Re: Comment to Application SEP 15-001

Re: CAO 15-001, SEP 15-001, VAR 18-002

Re: CAO 15-001, SEP 15-001, VAR 18-002  
Containment Wall Requirement

SOUTH ELEVATION

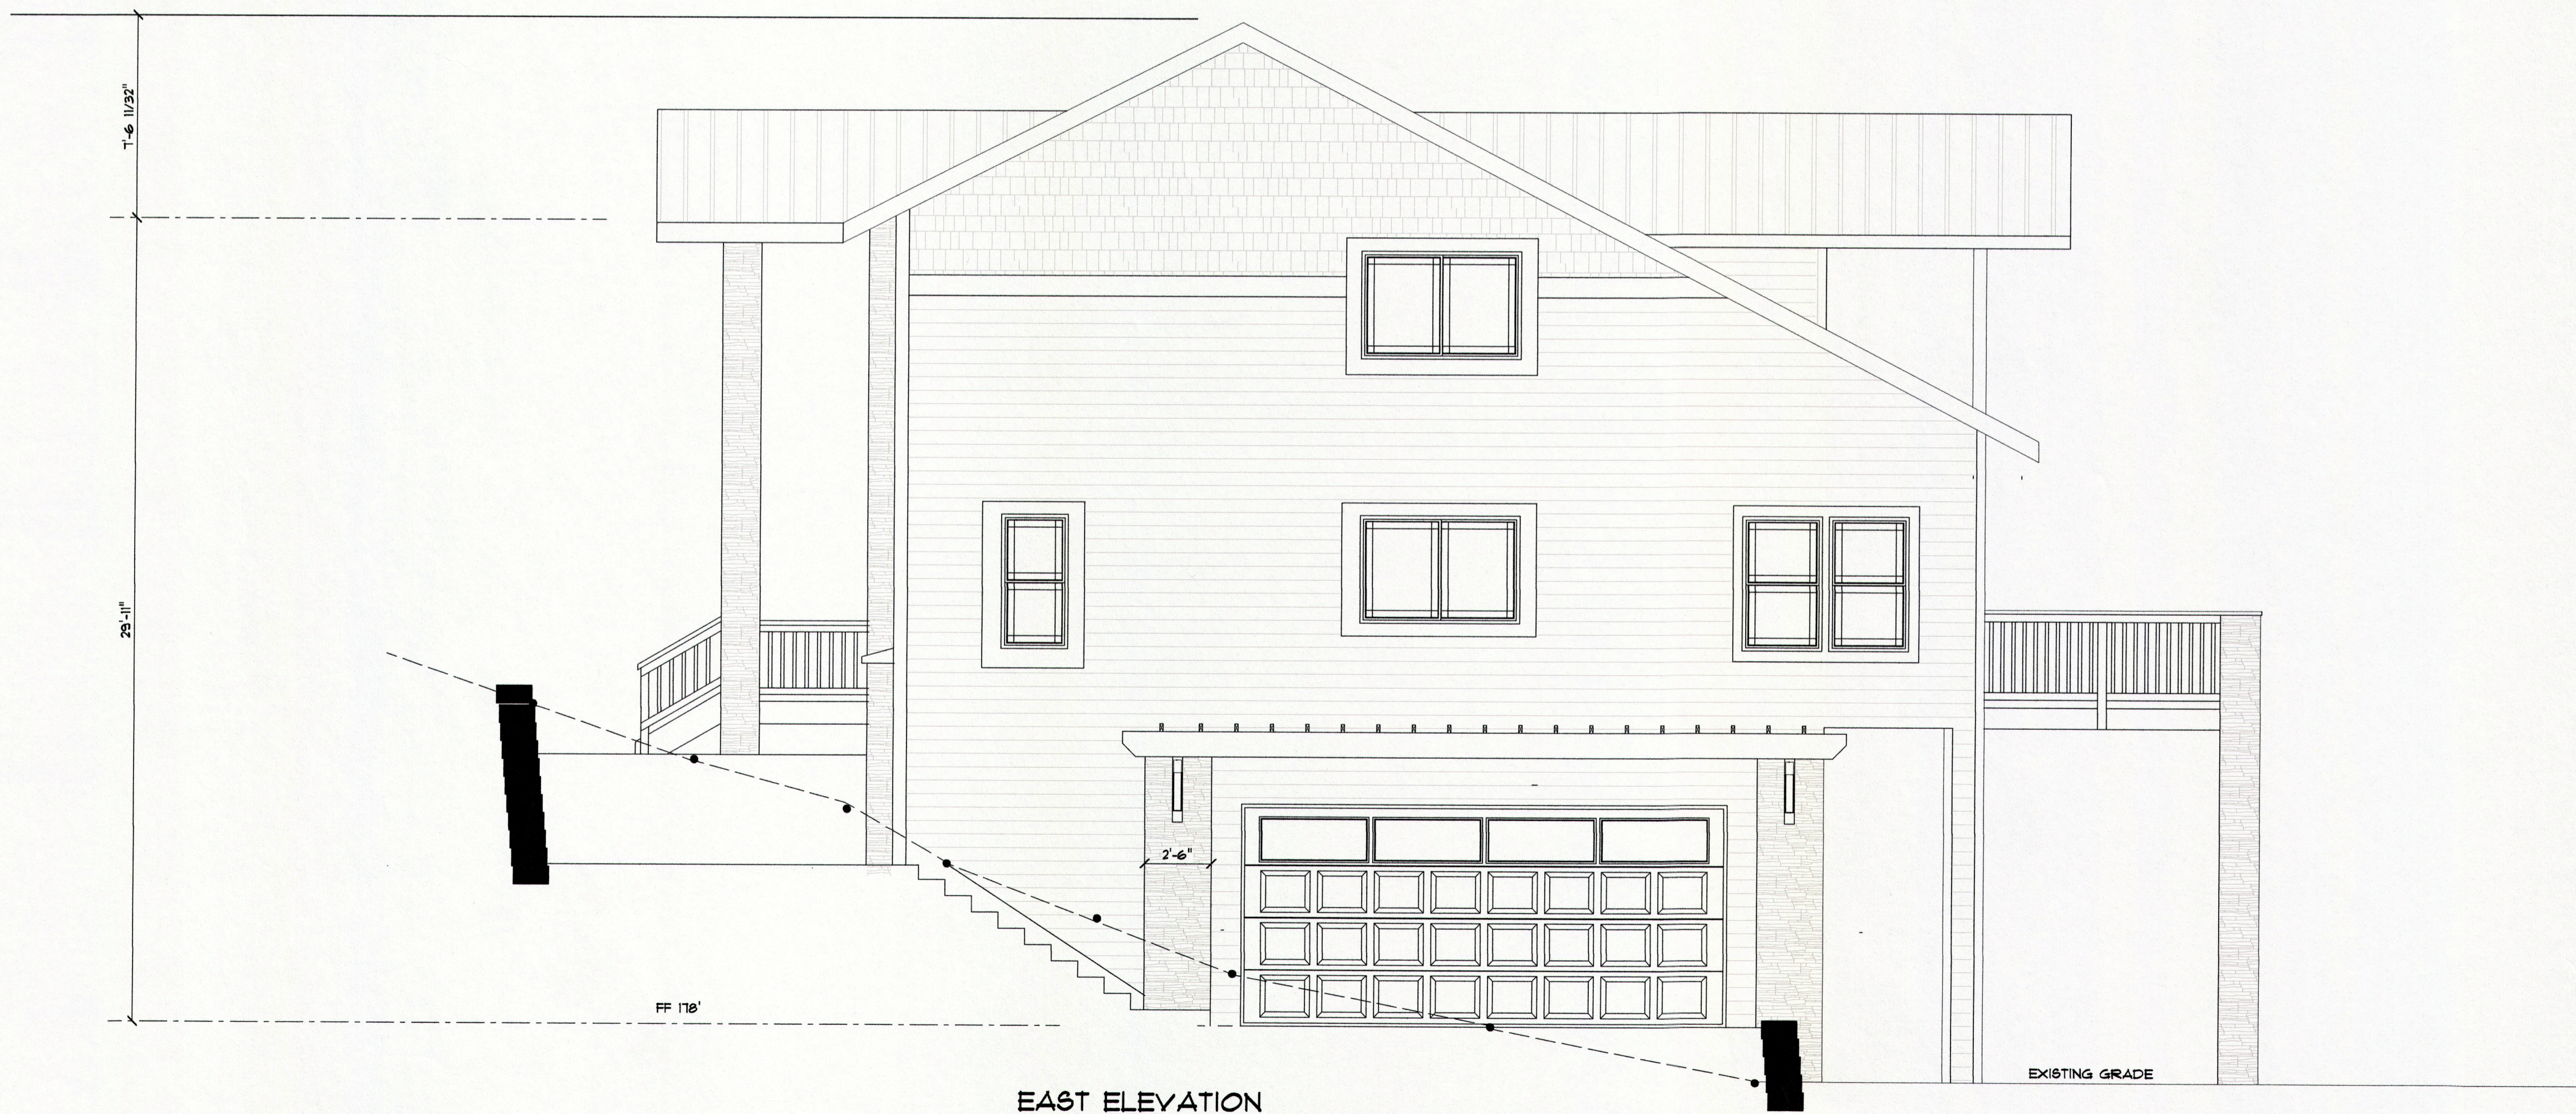
In a letter dated April 27, 2016, GEO refers to a catchment wall being incorporated into the building. However, there is no reference in the letter to the direction in which the catchment wall should be aligned. The GEO letter of October 2, 2015, refers to placing the wall “at or near the base of the steep slope south and southwest of the proposed residence location.” As shown by the topographic map above, the very steep slopes are to the southwest and south of the residence, and **not** to the southeast.

The plan submitted by Treehouse subsequent to the hearing shows a catchment wall built into the southeast wall of the residence facing the slope to the southeast. GEO had originally proposed in its letter of July 30, 2015, a catchment wall for the southeast wall of the residence, but this idea was subsequently abandoned. Rather, GEO recommended that “the wall alignment should run south of the residence **and continue around the southwest corner a distance of another approximately 20 feet.**” [Emphasis added.] Using the southeast wall of the residence as a catchment wall simply does not comply with this requirement. The proposed residence remains exposed to landslides from the steep slopes to the southwest and south of the residence. Aside from the topographic map, one can readily see from a visit to the site that the slopes to the southwest and south of the residence are far steeper, more precipitous, and much higher than the slope to the southeast.

Based on the foregoing, it is submitted that the current plan for the proposed residence does not comply with the safety criterion specified in 19.07.030(B)(3)(e). This is simply one of many reasons why the Treehouse application should not be supported by the City.
